18 July 2016
Our Ref: GLN10495_S96 UrbanGrowth

STATE SIGNIFICANT DEVELOPMENT NO.5093 – MOD 2 RESPONSE TO SUBMISSIONS

**Figure 2 Bridge Landing Pad and amended subdivision layout – Lot 103 and 113**

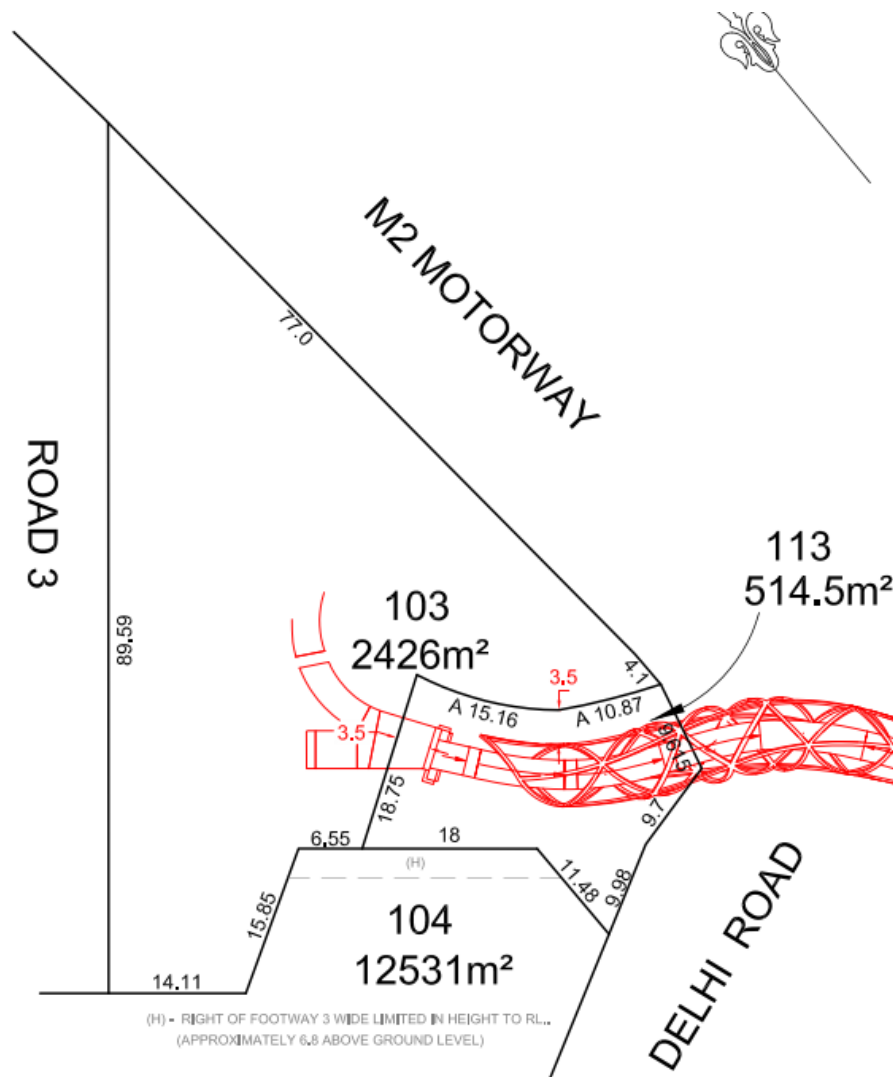
- *Proposed condition by RMS stating 'Updated subdivision plans to allow for dedication of the pedestrian bridge landing pad as public road'.*

UrbanGrowth NSW raise no objection to a condition imposed to this effect. The proposed lot to be dedicated is Lot 113 measuring 514.5m². A suggested condition is proposed below:

'Lot 113 shall be dedicated to NSW Roads and Maritime Services as a public road'.

TITLE: EARTHWORKS LAYOUT PLAN - OPTION 1

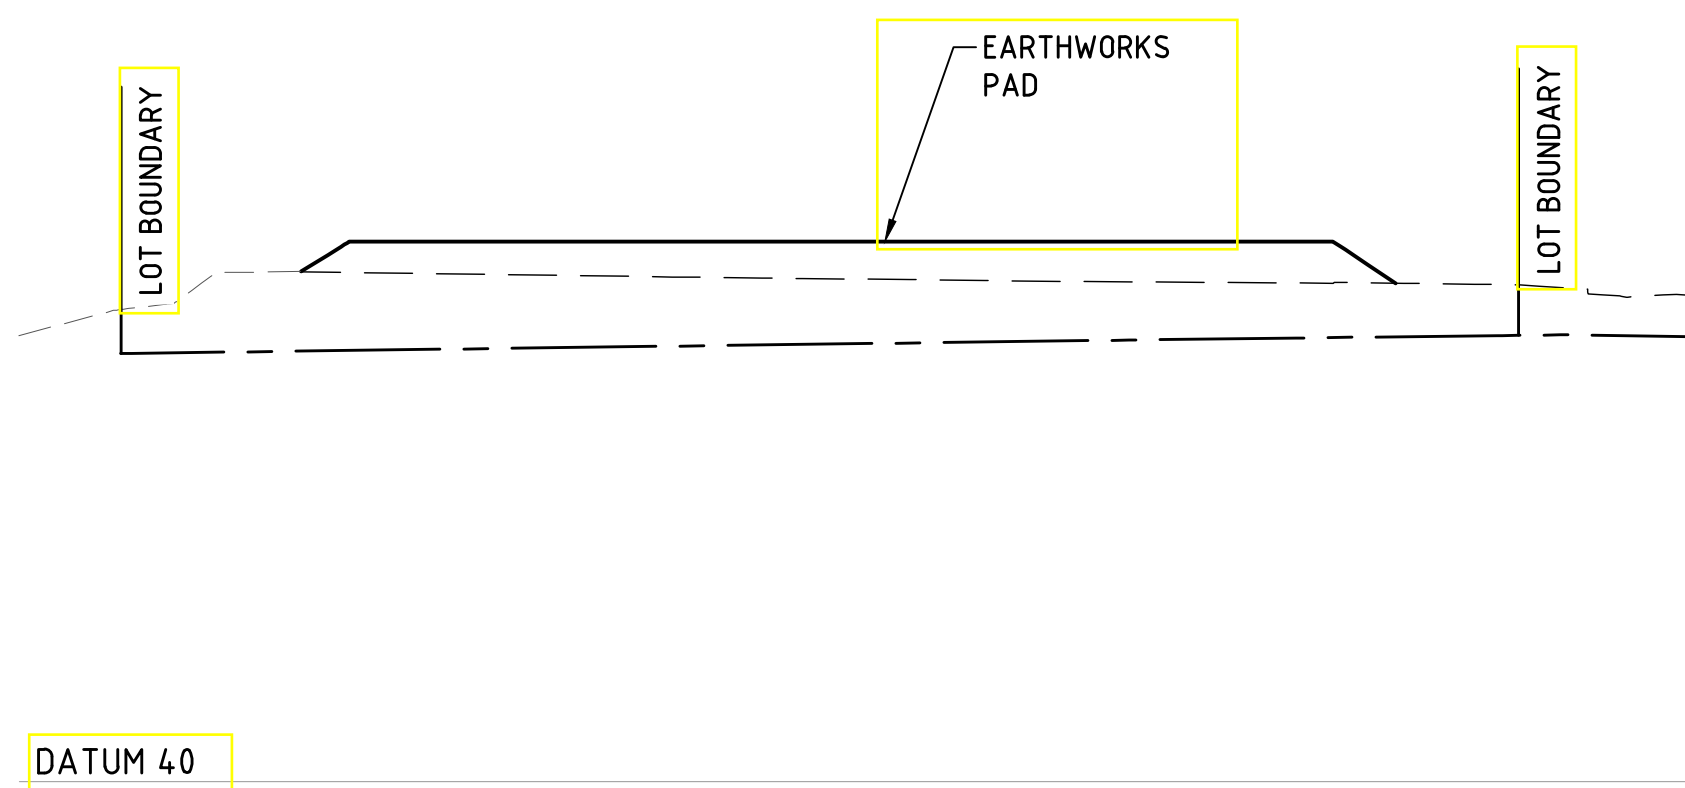
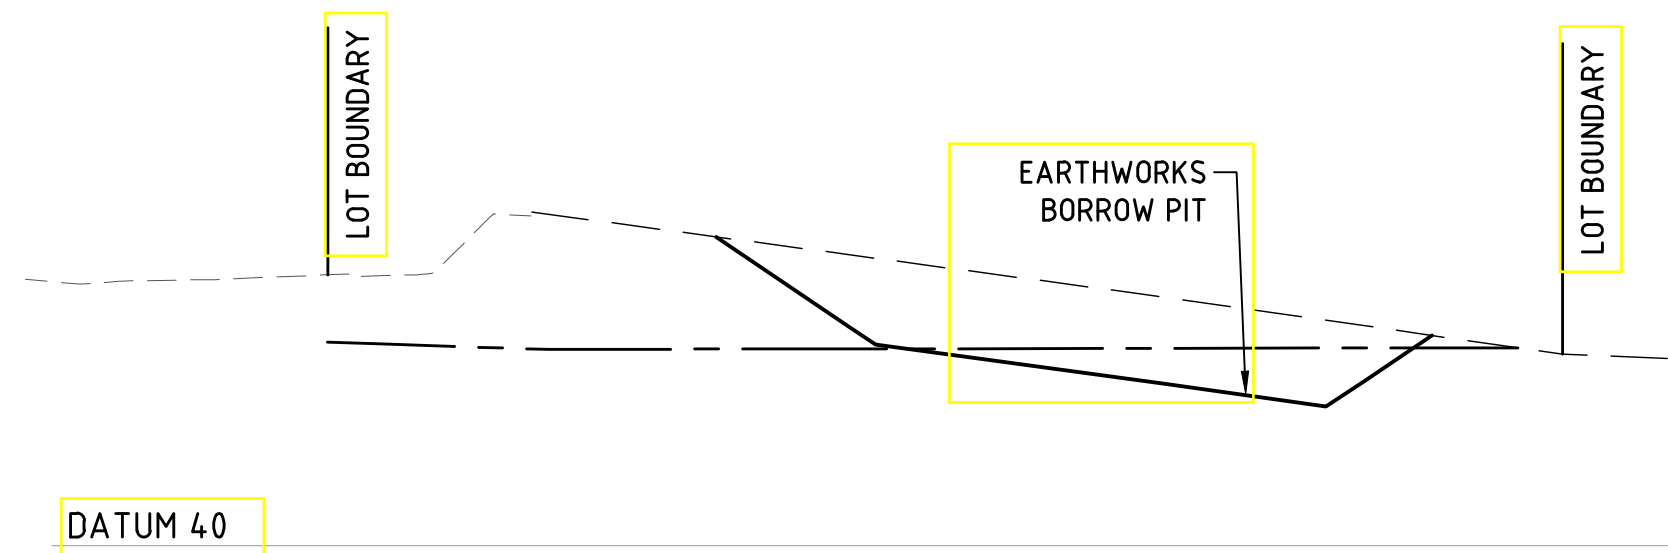
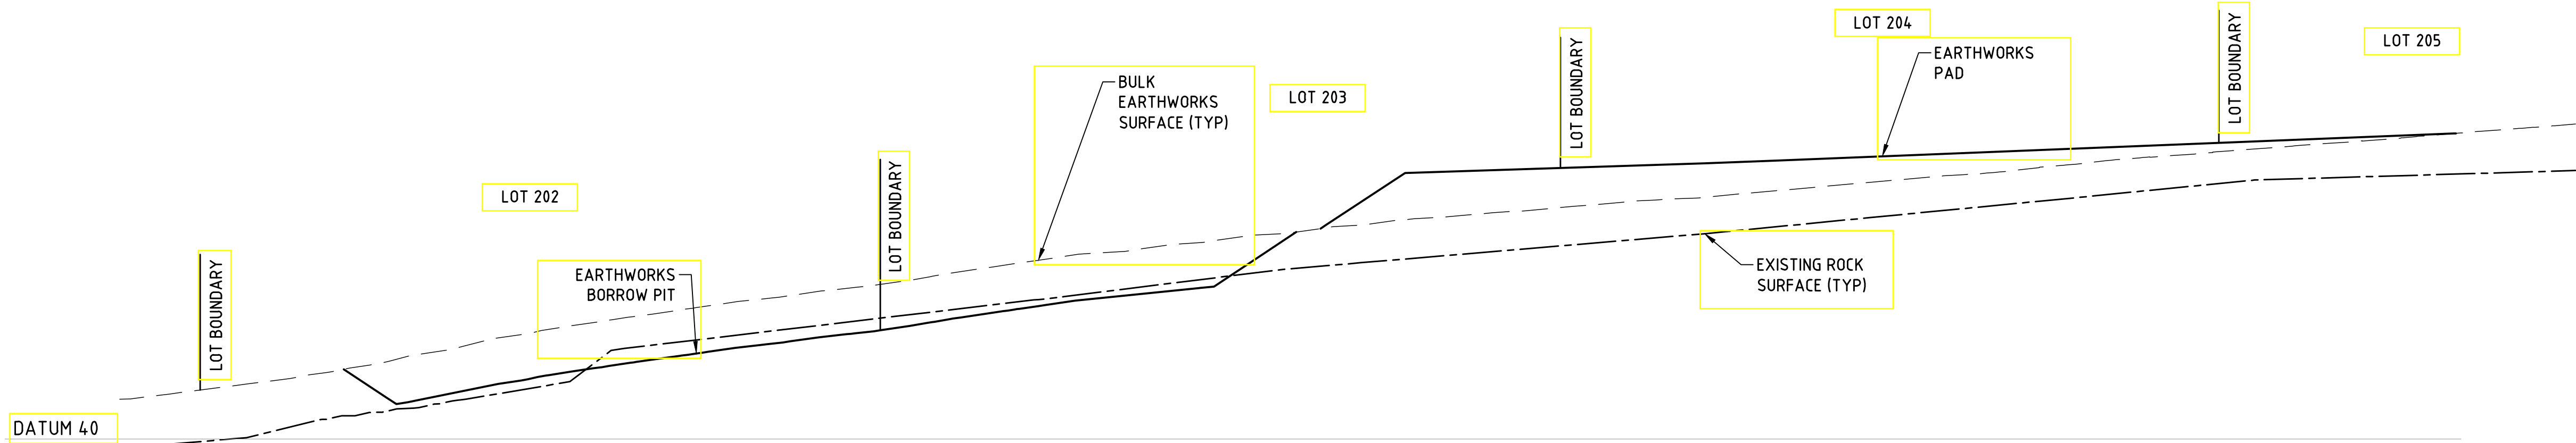
- Department of Primary Industries
 - Excavation of borrow pit – interception of ground water

Based on geotechnical investigations, ground water is located approximately 5 to 8 metres below the ground level in the vicinity of the borrow pit. The borrow pit is proposed to be cut to a maximum depth of 3 metres and hence it is not anticipated and most unlikely that ground water will be encountered with this work. If DPE sees it necessary, the following condition could be imposed to address this concern:

‘Should groundwater be intercepted during the excavation of the borrow-pit, the works shall cease and the applicant shall consult with Department of Primary Industries to confirm whether a licence for temporary dewatering associated with the construction activity is required. Should DPI determine a licence for dewatering is necessary, this shall be obtained prior to any further works continuing.’
